Application for Non-material Amendment to Reserved Matters Approval ref. 15238/23

Plot 3, Wingates Industrial Estate, Great Bank Road

Panattoni are seeking to make non-material amendments to Reserved Matters Approval ref. 15238/23 [the RMA] in respect of an additional substation, increased provision of solar photovoltaic panels and other minor changes to external design. This necessitates the substitution of drawings and associated changes to the wording of conditions 2 (approved plans), 5 (car parking spaces), 7 (access), 9 (landscape scheme) and 14 (external lighting) attached to the RMA.

drawing title: **Proposed Roof Plan**

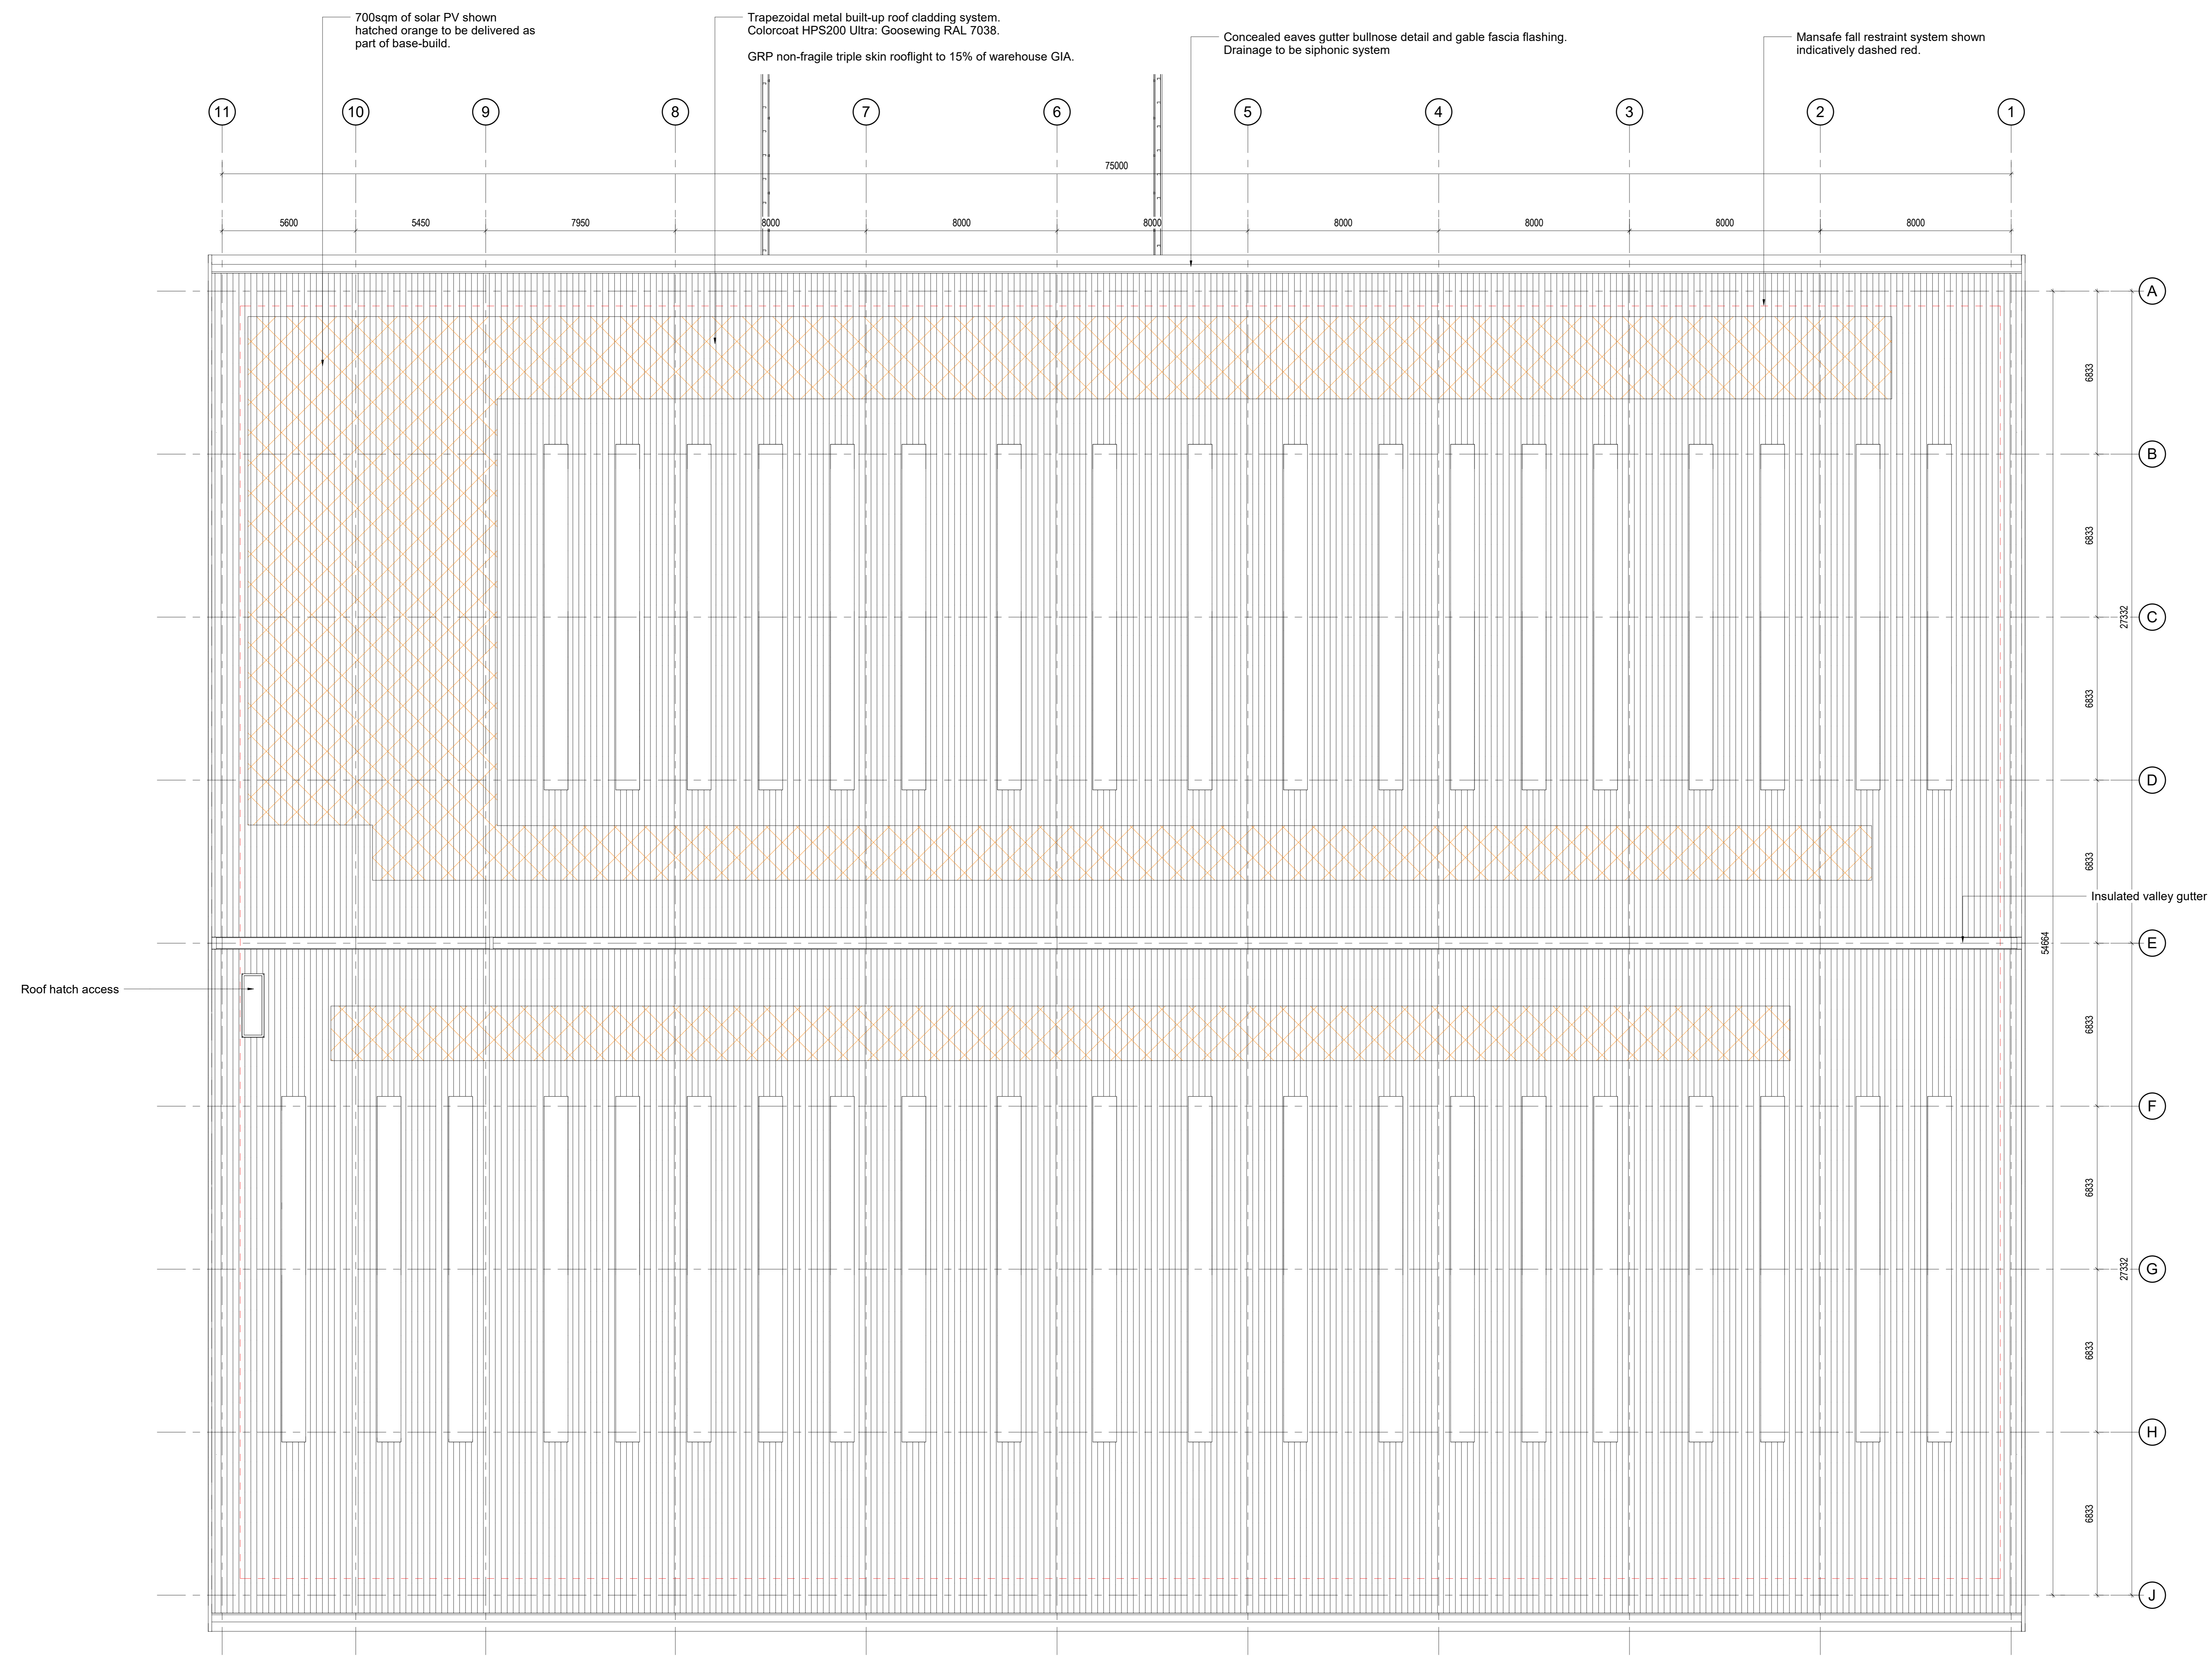
- 2 An increase in the extent of solar photovoltaic [PV] panels located on the roof of the building, from 165sqm to 700sqm.
- 3 The substitution of 3 lighting bollards located opposite the pedestrian entrance of the building with 2 wall mounted lighting fixtures (EX3).

In relation to the solar PV panels, an Energy Statement [ES] prepared by CPW was submitted with the RMA while it was being considered by the local planning authority [LPA]. CPW based their assessment of the sustainability of the development on 165sqm of roof mounted solar PV panels and an air source heat pump. The LPA accepted the ES by requiring the development be built in accordance with its recommendations (condition 4 attached to the RMA). CPW considered that 165sqm of solar PV panels plus an air source heat pump would deliver a 10% reduction in CO2 emissions. The proposed 700sqm of solar PV panels amounts to a 324% increase in PV panels which will help to further reduce the building's CO2 emissions. Please refer to the Proposed Roof Plan for full details (ref. 12737-AEW-03-RF-DR-A-0512 rev. P06). This increase is considered to accord with the sustainability requirements contained within the emerging Places for Everyone [Pfe] in which the Inspectors Main Modifications [MM] were published on 15 February 2024. For example, draft Policy JP-S2 (carbon and energy). The Inspectors concluded their MM made the Plan sound and the emerging Pfe will now be submitted for approval by the nine local authorities.

As per the approved ES, the solar PV panels will be positioned at a 30 degree angle facing south to allow maximum exposure to sunlight. This positioning will reflect sunlight in the opposite direction to the homes located north of the site. It is considered unlikely that residents will therefore be adversely affected from glare from the PV panels. Due to the betterment in terms of sustainability credentials and lack of glare anticipated, the proposed increase in solar PV panels is considered to be acceptable and non-material. For completeness and as noted, the approved roof plan includes a note identifying that up to 1,062sqm of PV panels could be located on the roof based on the rooflight configuration. The proposed increase in PV panels to 700sqm amounts to 66% of the potential maximum extent noted on the roof plan. The proposed extent of solar PV panels is within the potential maximum extent previously approved by the LPA.

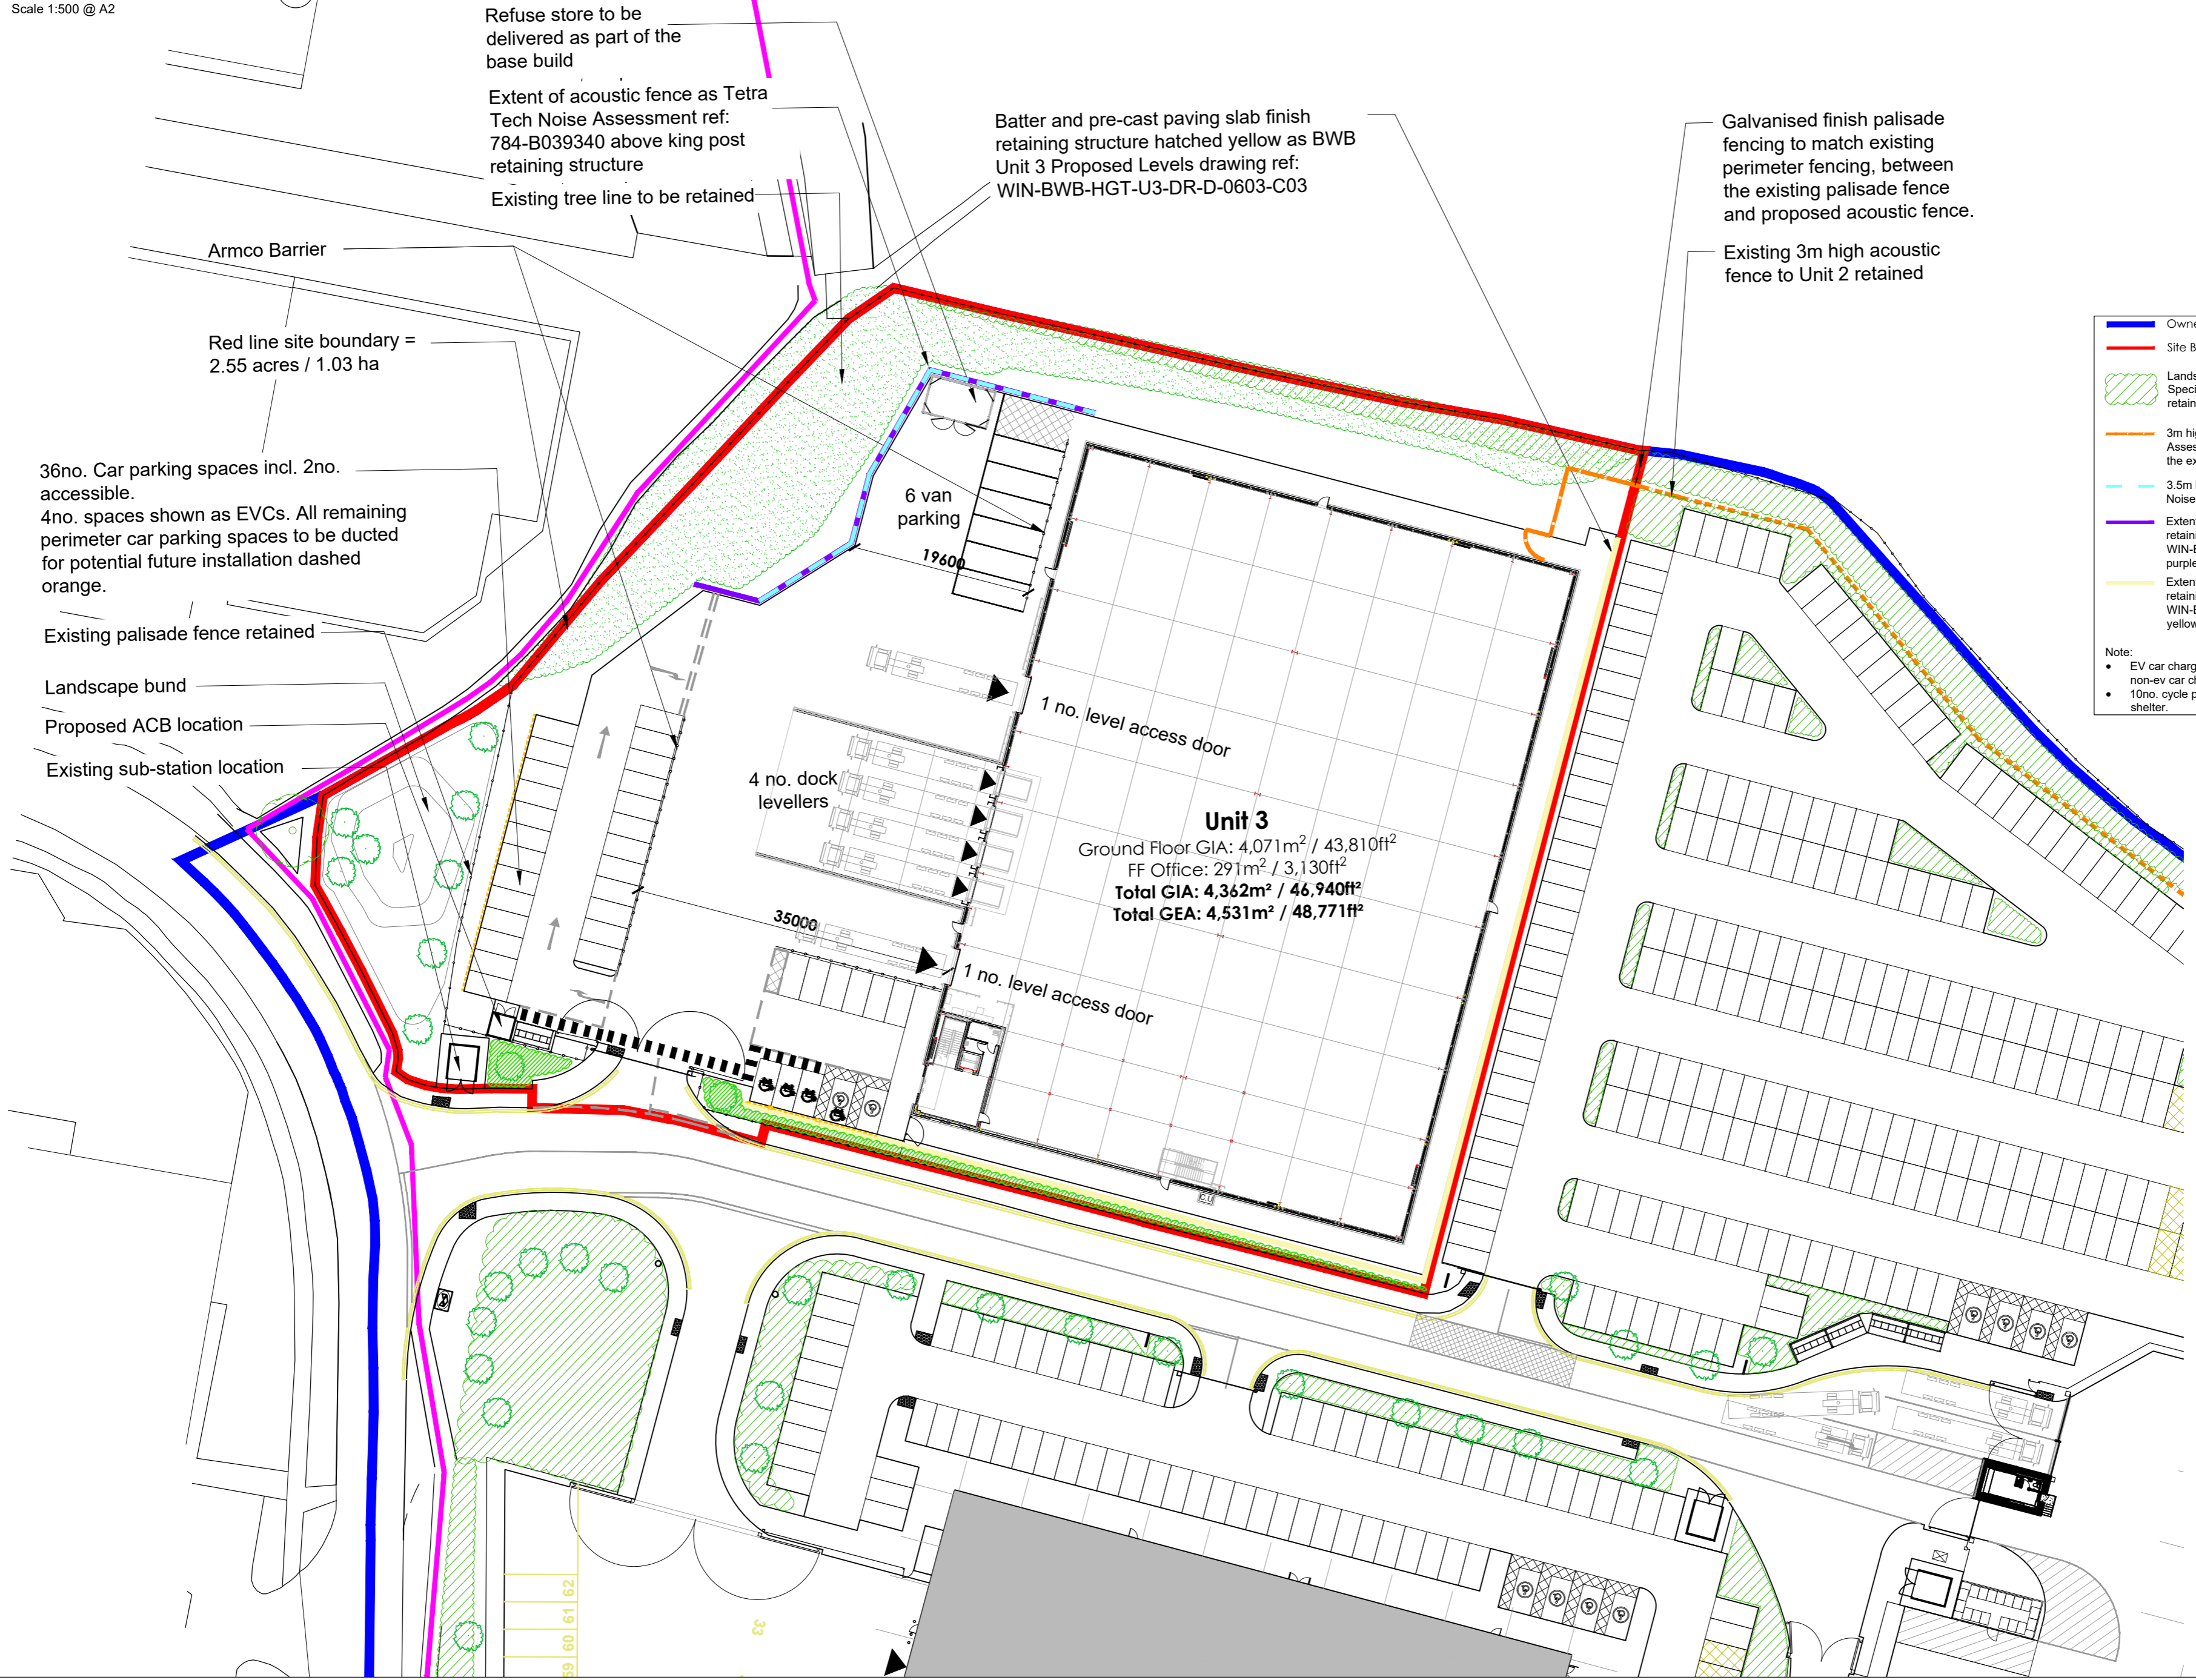
- 4 The installation of an access gate for maintenance access within the 2.4 metre high paladin perimeter fencing located at the southwest corner of the building.

- 5 Extension of the perimeter footpath on the eastern side of the building by 2m in length (at its northeast corner) and associated realignment of adjacent timber fence and gate.

- 6 The relocation of the electric vehicle charging upstands within the car park (no change to quantum).

The newly proposed access gate is located within the perimeter fence at the southwestern corner of the building. Please refer to the Proposed Boundary Treatment Plan for details (ref. 12737-AEW-03-ZZ-DR-A-0506 rev. P12). This gate will allow maintenance access from the car park to the side footpath and around the perimeter of the building. Two of the building's emergency exits open onto the enclosed perimeter footpath. The secondary access gate is therefore considered to improve the safety of the occupants of the building in an emergency situation by adding a secondary exit from the perimeter footpath. The proposed gate will match the height, materials and colour scheme of the approved 2.4m high paladin perimeter fence. No changes are proposed to the perimeter fence otherwise. The proposed amendment is not considered to be discernibly different to the approved perimeter fence in terms of

In respect of the perimeter footpath, the section running parallel with the eastern elevation is proposed to be extended north by 2m. The extension is necessary to allow space for a Mobile Elevating Work Platform [MEWP] to manoeuvre around this corner. The MEWP is needed for building maintenance. The adjacent timber fence and access gate has been relocated accordingly. Please refer to Figure 2 below, the Proposed Site Plan and the Detailed Planting Plan for full details (ref. 12737-AEW-03-ZZ-DR-A-0503 rev. P18 and 02 rev. B, respectively). A small area of grassland shown on approved Soft Landscaping Plan (sheet 1 of 2 ref. 12176_P10 rev. C) will be removed to facilitate this change. There will be no loss of any trees or shrubs, nor adversely impacting on biodiversity. The proposed extension is required for operational reasons and is minor in the context of the approved development; it is again clearly non-material.

With regards to the electric vehicle [EV] upstands, the approved EV Charging Details Plan (ref. 12737-AEW-03-ZZ-DR-A-0516 P2) includes two upstands that serve four out of the five parking bays located adjacent to the main entrance of the building. The current parking bays served by the two upstands comprise two disabled bays and two regular parking bays. There are, however, three regular parking bays in this location (five parking bays in total). The two EV upstands are proposed to be relocated so that they would serve three regular parking bays and one disabled bay. This would mean that one out of the two disabled bays were still served by an EV upstand. For the avoidance of doubt, no changes are proposed to the quantum of disabled parking bays. Please refer to the Proposed EV Charging Details Plan for details (ref. 12737-AEW-03-ZZ-DR-A-0516 rev. P5). The amendment is proposed to ensure the disabled bays are only used by staff and visitors who require the disabled parking space rather than by

- Proposed Site Plan 12737-AEW-03-ZZ-DR-A-0503 P8 12737-AEW-03-ZZ-DR-A-0503 rev. P18

“Before the approved development is first occupied no less than 36 car parking spaces shall be marked out and provided within the curtilage of the site in accordance with the Proposed Site Plan prepared by AEW (ref. 12737-AEW-03-ZZDR- A-0503 rev. P8) (ref. 12737-AEW-03-ZZ-DR-A-0503 rev. P18). Such spaces shall be made available for the parking of cars at all times (the premises are in use).”

“No part of the development hereby approved shall be occupied until the access road(s), footway(s) and footpath(s) leading thereto have been constructed and completed in accordance with the approved Proposed Site Plan 12737-AEW-03-ZZ-DR-A-0503 P8 (ref. 12737-AEW-03-ZZ-DR-A-0503 rev. P18).”
